DRB Application No.: 05DRB-00055 (P&F)	Project # 1003592
Project Name: SCHMIDER PARCEL	
Agent: Forstbauer Surveying	Phone No.: 268-2112

RE: Lots 1 & 2/Schmider Parcel/ minor plat

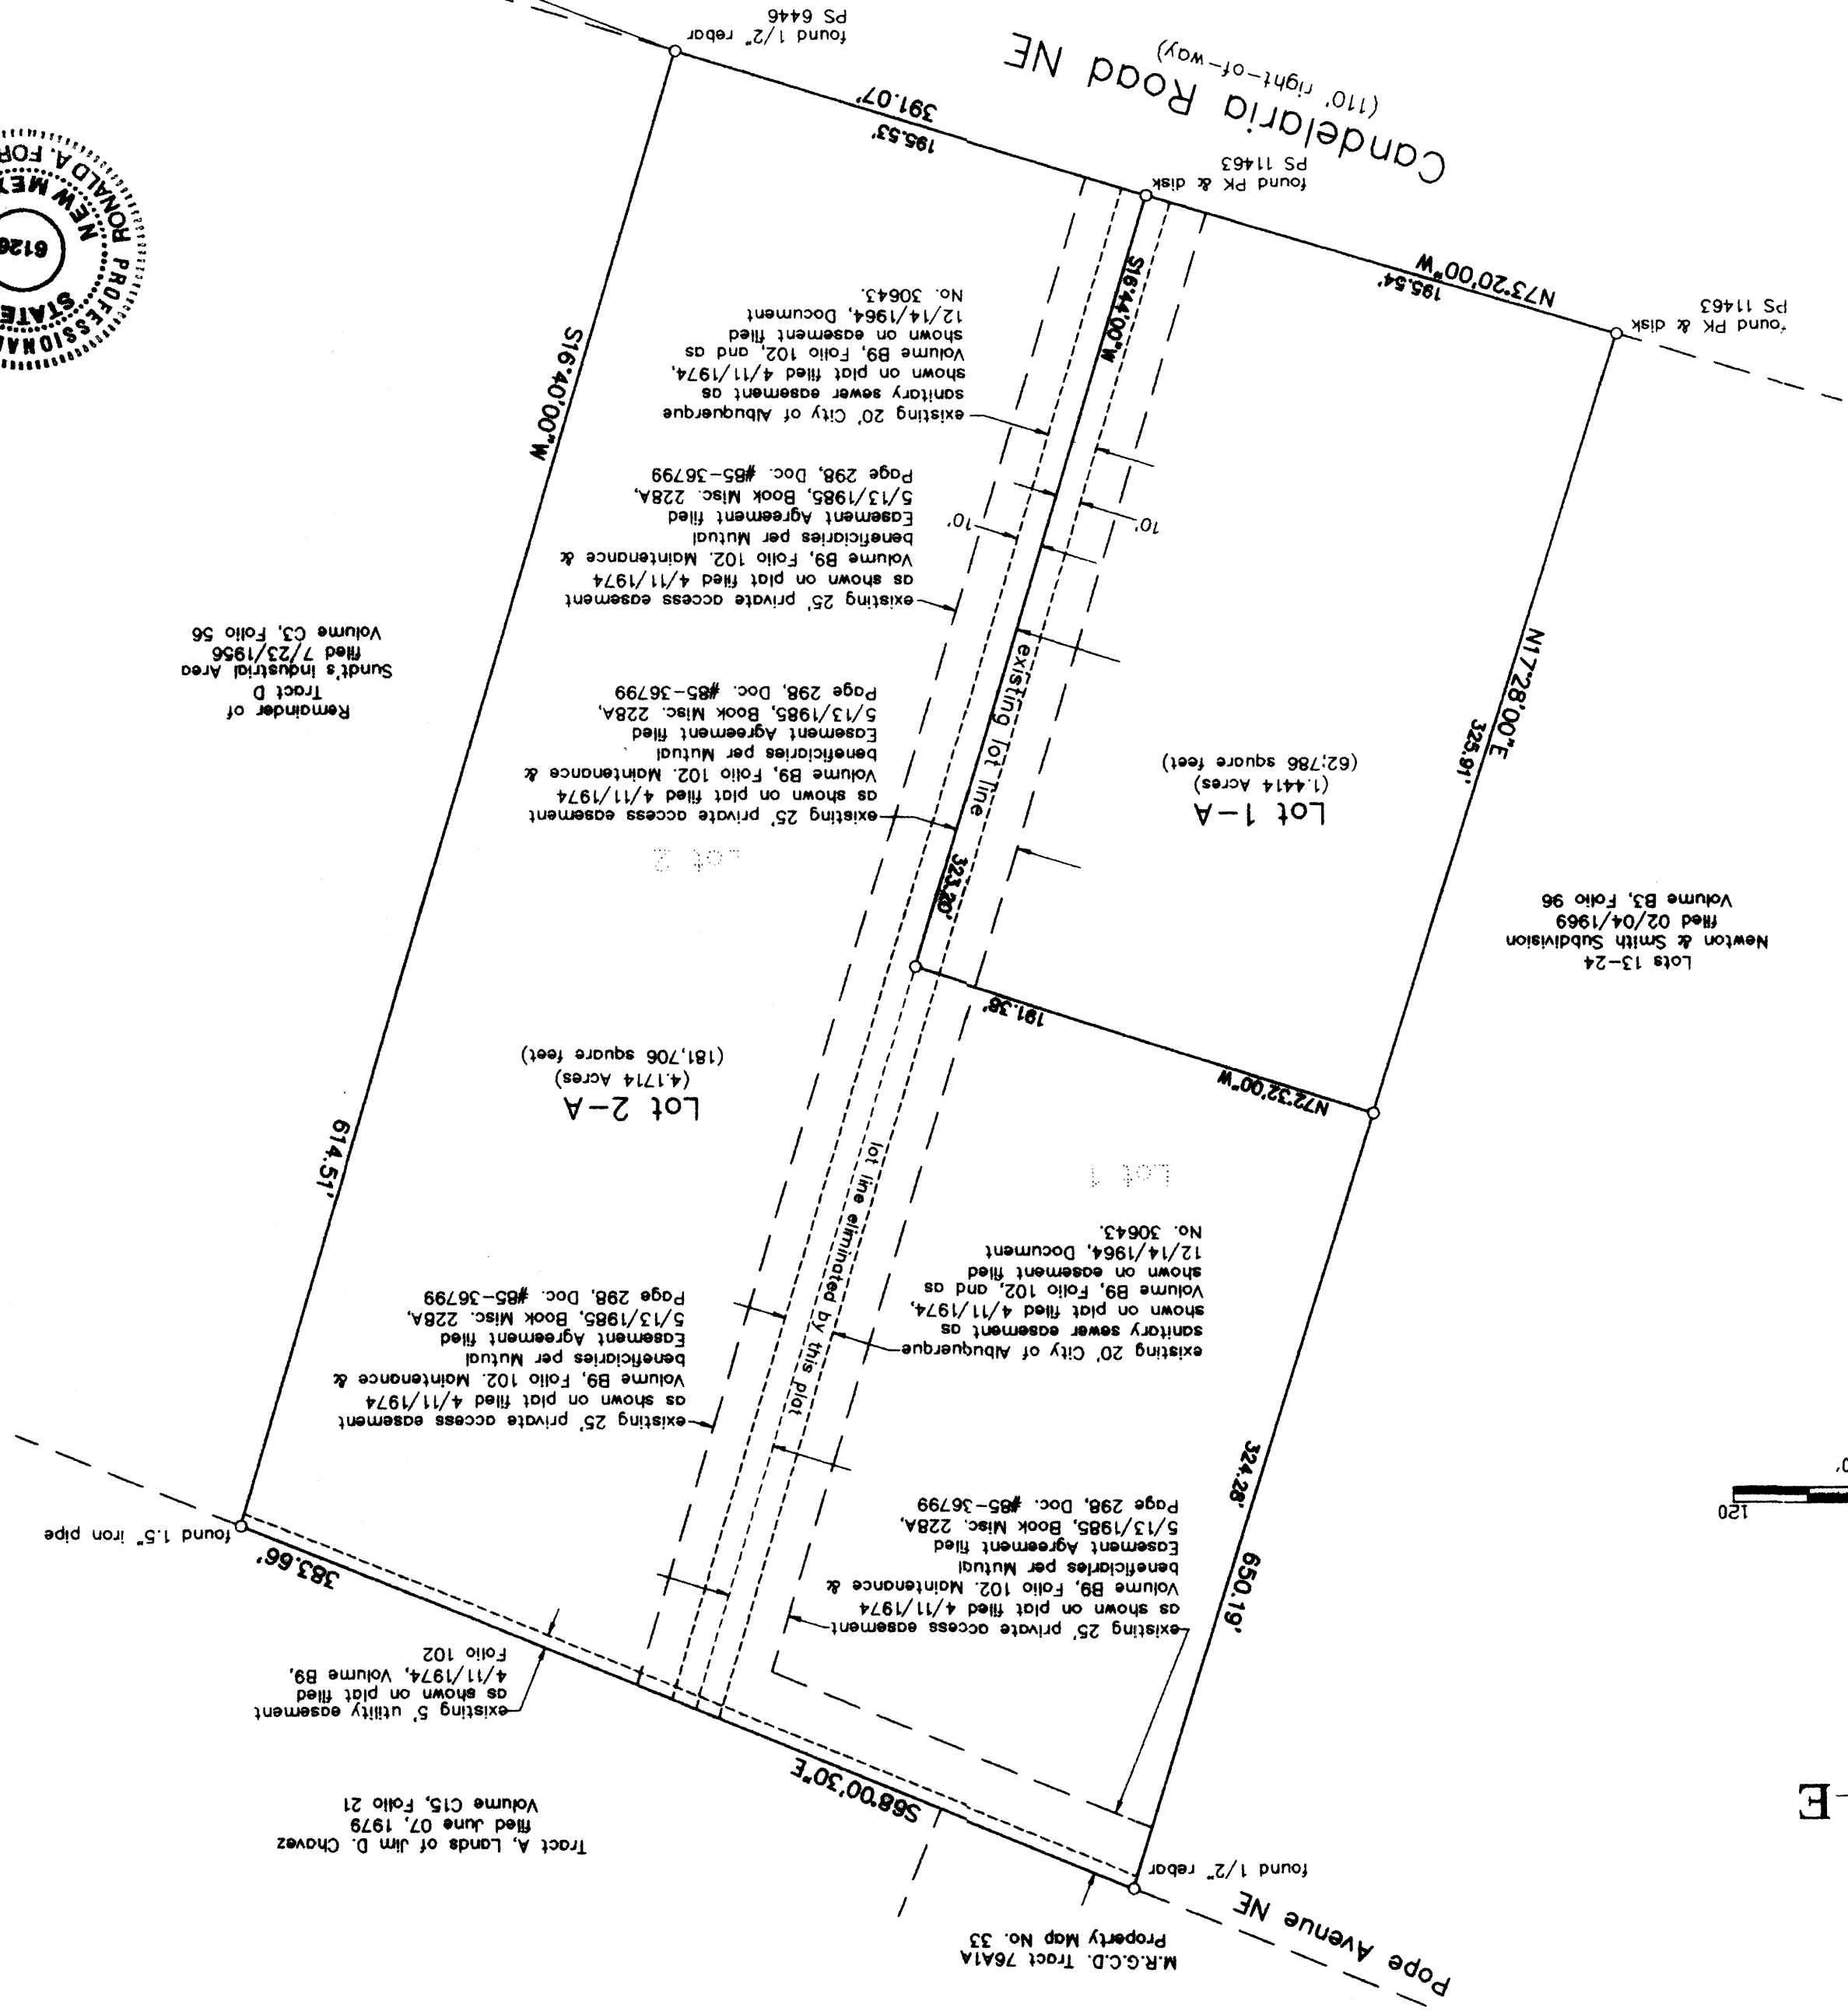
Where is the new lot line?

The City's Subdivision Ordinance requires that all lots have availability to water/sewer/fire protection. With the subdivision of the existing lot, the rear lot will not have water service or fire protection. There are no water lines in Pope Ave, but there is a sewer line.

Therefore any subdivision will require extension of a public water line in Pope Ave. as a condition of plat approval.

A fire flow calculation requirement for the existing structure should also be provided to me for verification of adequate fire protection of the existing structure.

Need cross-lot drainage easement.
